From: Thomas Callaway
Sent: 08 April 2015 13:43
To: Planning.Responses
Subject: RE: Planning Consultation on BE/41/15/DOC

APPLICATION BE/41/15/DOC
NO:

Registered: 15-MAR-15
Site Address: 346 Chichester Road Bersted PO21 5BX

Application for approval of matters reserved by condition imposed under BE/114/14/PL relating to conditions 4, 5 & 9 for surface water drainage, dustbin enclosure details & construction management plan.

PROJECT	Standard Detail High Storage Soakaway	SA/1A/12
DRAWN BY	CHECKED BY	DESIGNED BY
R.J.L	PEF	R.J.L
SCALE	DATE	
N.T.S.	MAY 03	
STD NO.	REVISION	
STD.01.63		C

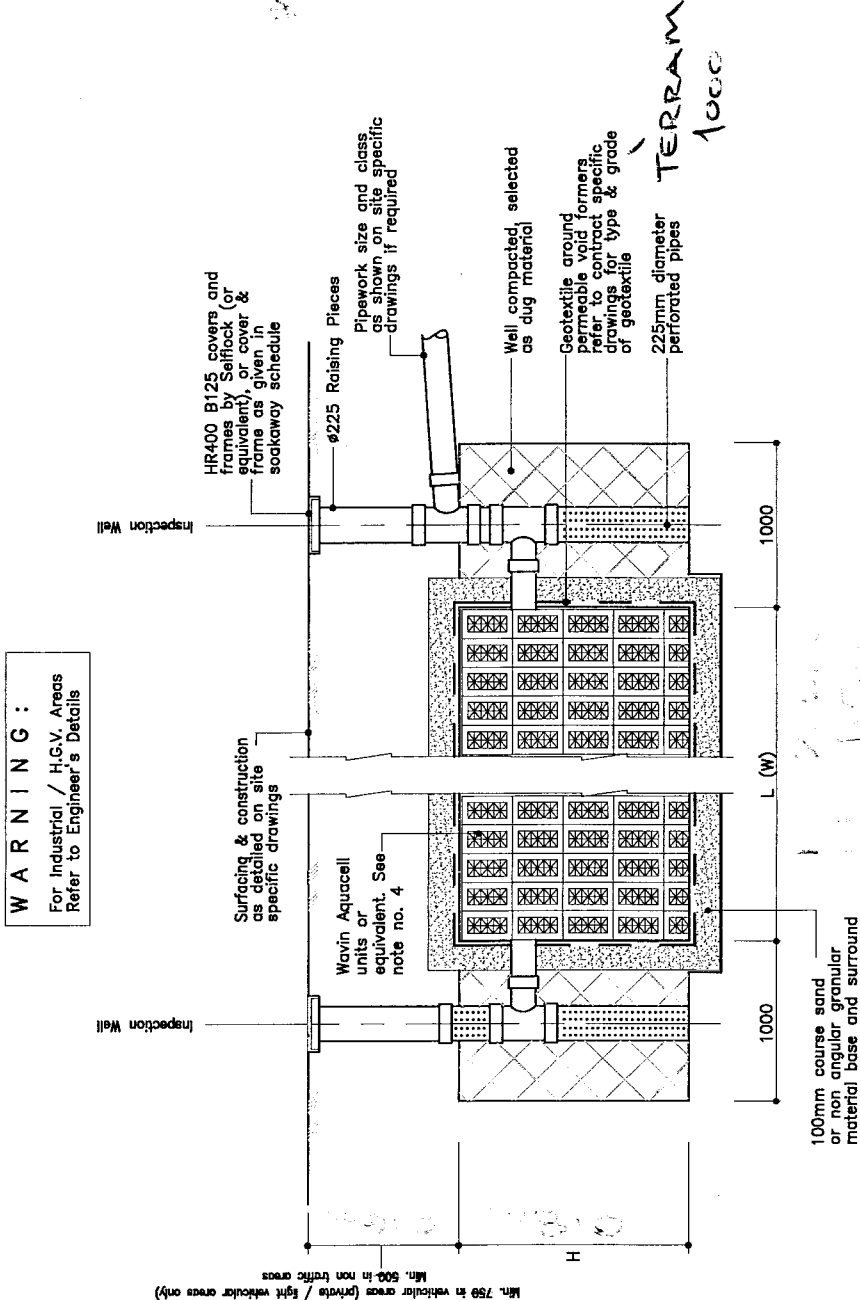
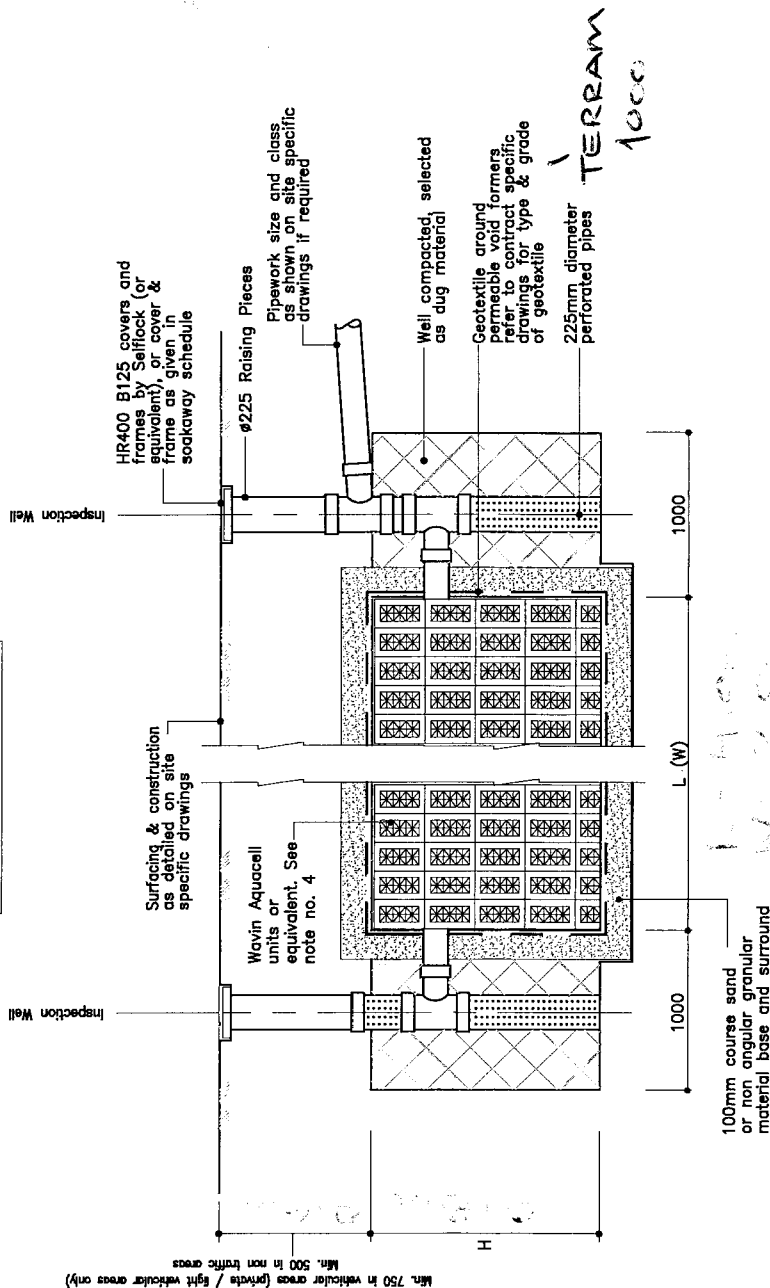
Soakage rates are low enough that the soakaways will not drain half of their volume within 24 hours. For other applications where this has been the case, we have asked that the storage be increased to allow for surface water from any subsequent storm.

Please could the storage be increased enough so that the spare volume expected from a soakaway with a better half drain time (max. 24 hours) is incorporated into the design. In this case a 25% increase may be suitable, but it should be fully calculated.
